Submission on Application to An Bord Pleanála under  
S. 37 of the Planning and Development Act 2000

*Application Ref:* 07.302848

*Development:* N6 Galway City Ring Road (N6  
GCRR)

*Location:* Aughnacurra, Lower Dangan,  
Galway.

A.12.3.3

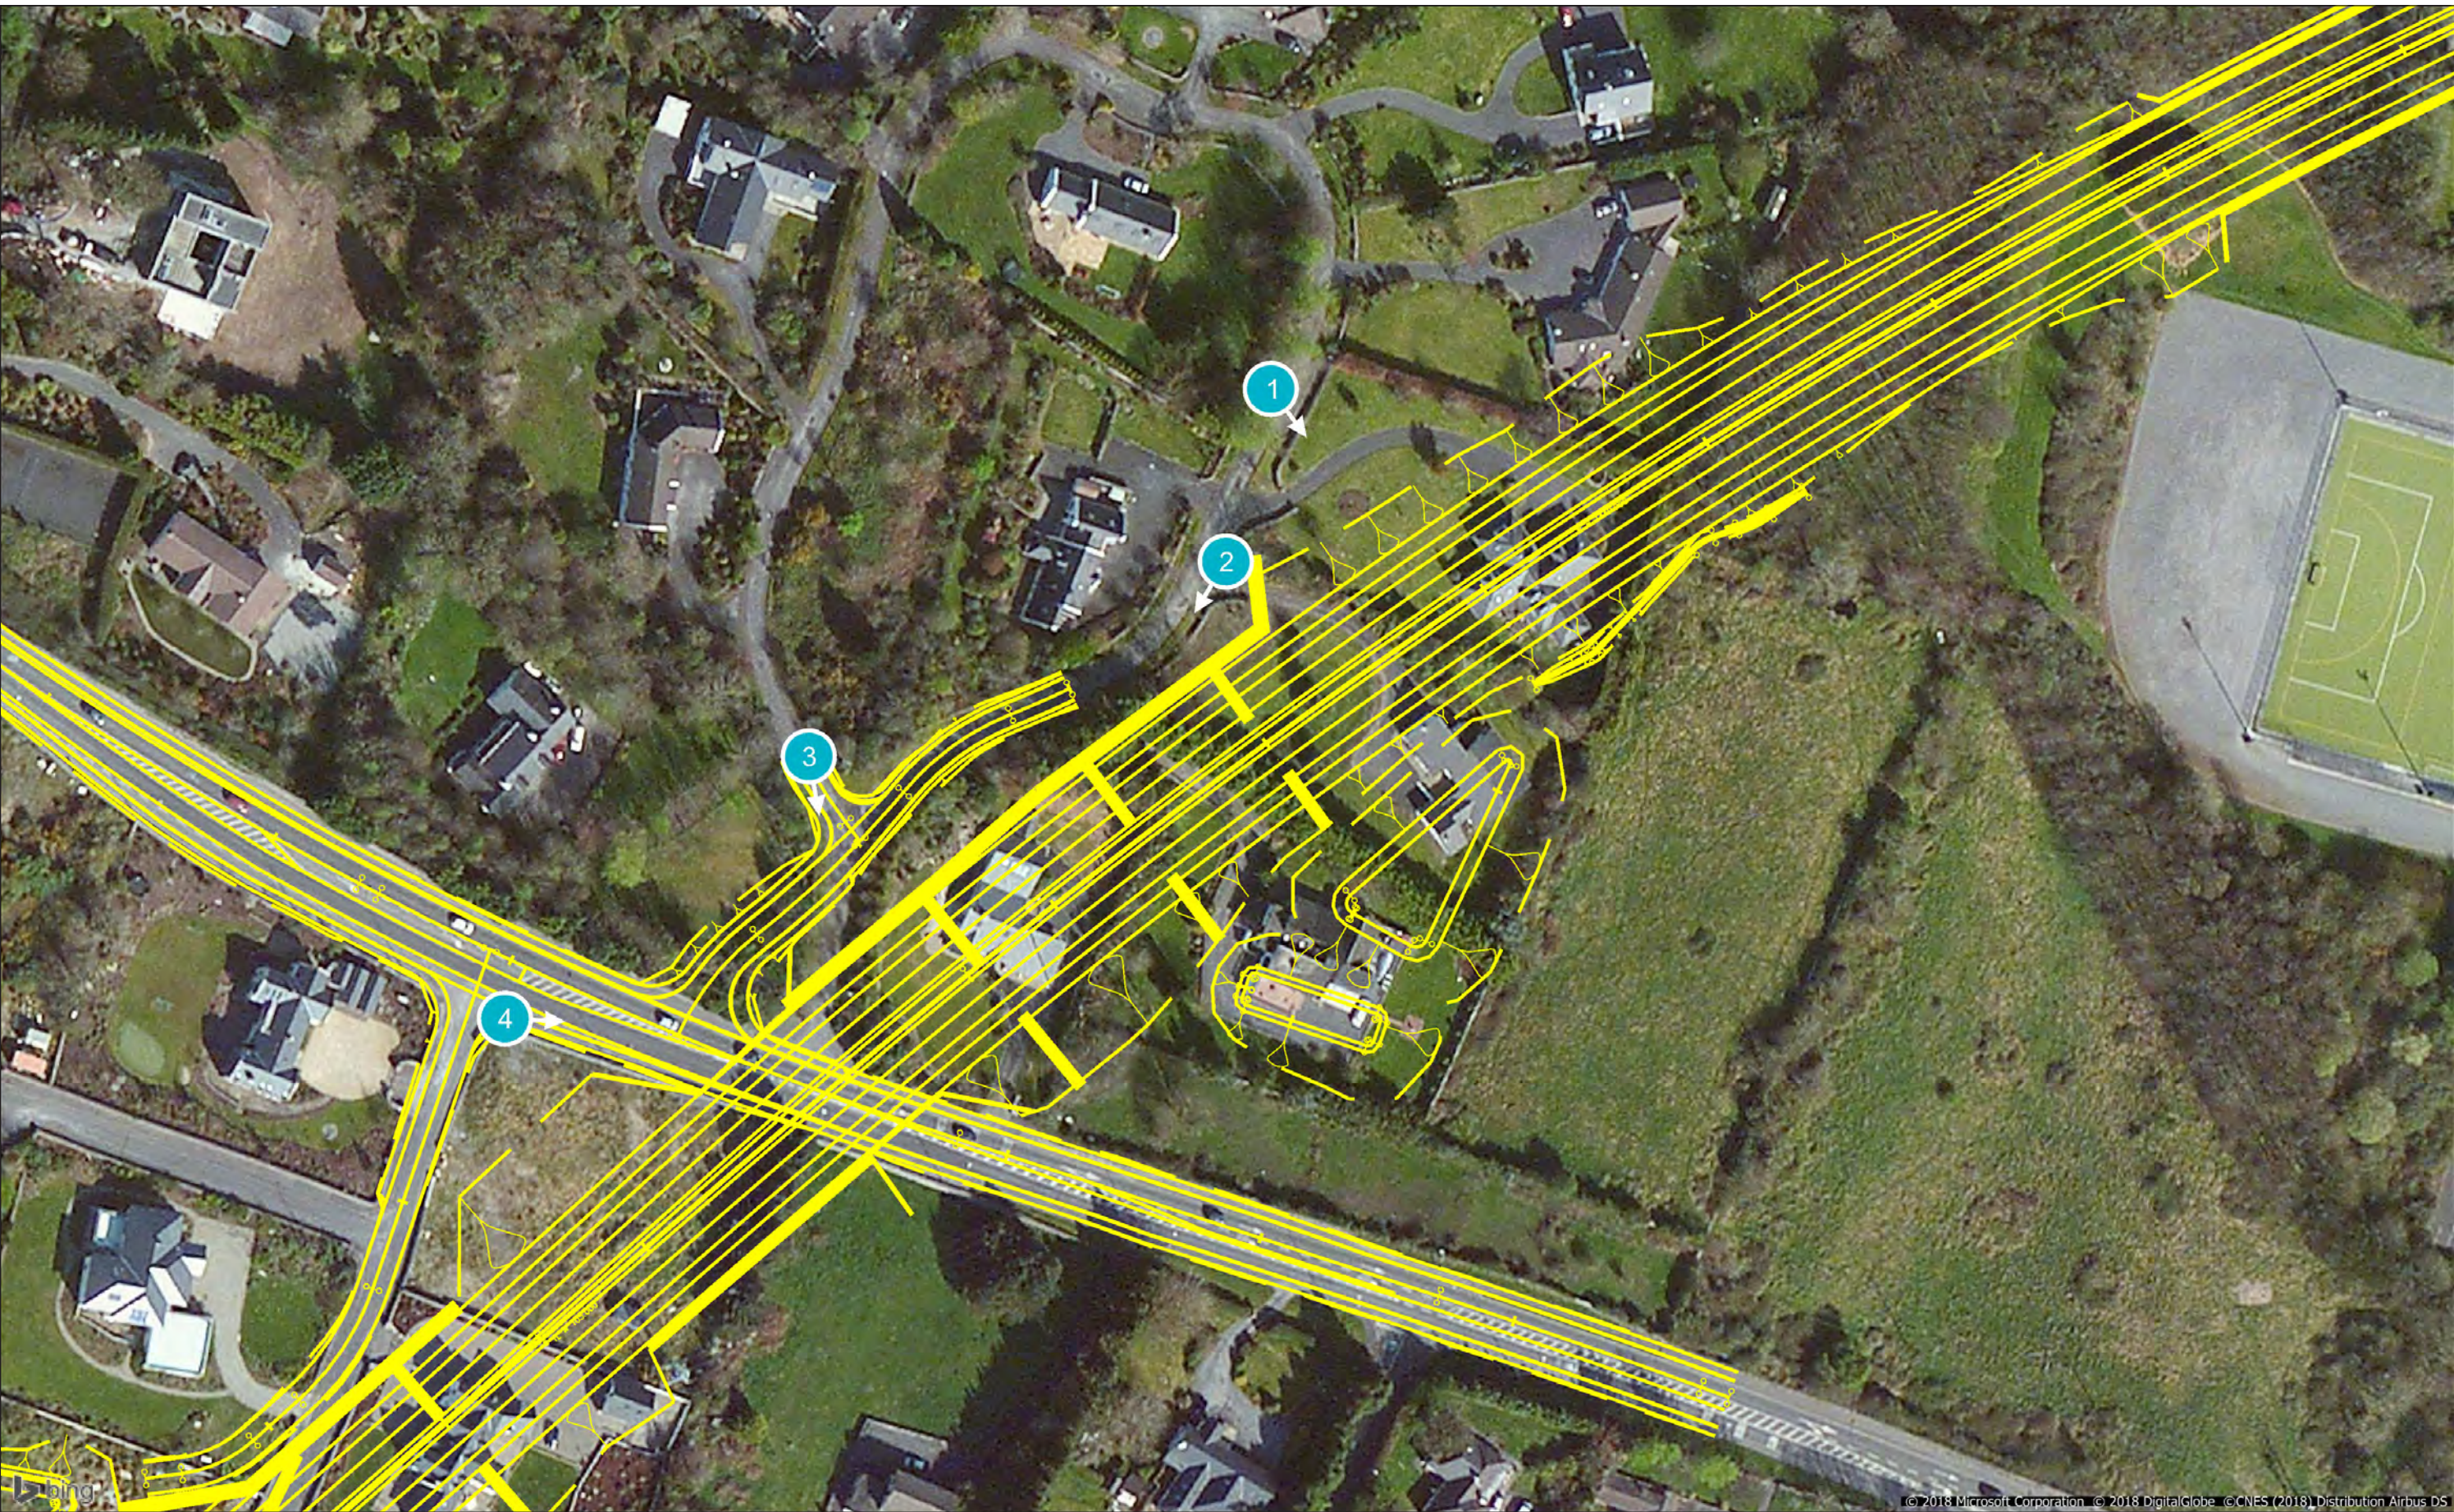
We are residents of Aughnacurra, Lower Dangan, Galway. Our home while not within the Development boundary is profoundly impacted by the motorway. We currently live in a very quiet settled residential area of 14 homes, and our lives are about to be turned upside down, both during the multi-year construction period and post the completion of the Development, as our home will be less than 30 metres from the elevated motorway. We will be living within a stones throw of a motorway and flyover that is more suited to downtown Los Angeles than the city of Galway. The motorway will sever the estate I live in, and will destroy the quality of life for our family. While we accept a river crossing is needed, we are bewildered that the result is our lives are destroyed by a motorway that cuts through such a heavily populated part of the city and destroys so many lives. As citizens we have a profound sense of dislocation and disillusionment with the State and the process. To try to illustrate the impact upon our family we attach before and after photomontages of the view of the motorway from our back garden. (Ref Map 1a and 1b)

The motorway will be very visible from our back garden. It will be a terrible sight, and a constant reminder that we are living at the edge of an elevated motorway. We are told the planting in this area will take 15 years to mature, and to shorten the time from commencement of planting to when the motorway is screened, we are requesting the construction of a gentle upward slope from the current boundary wall to the base of the motorway. The specific location we are referring to is the base of the boundary wall at what is currently 9 & 10 Aughnacurra.
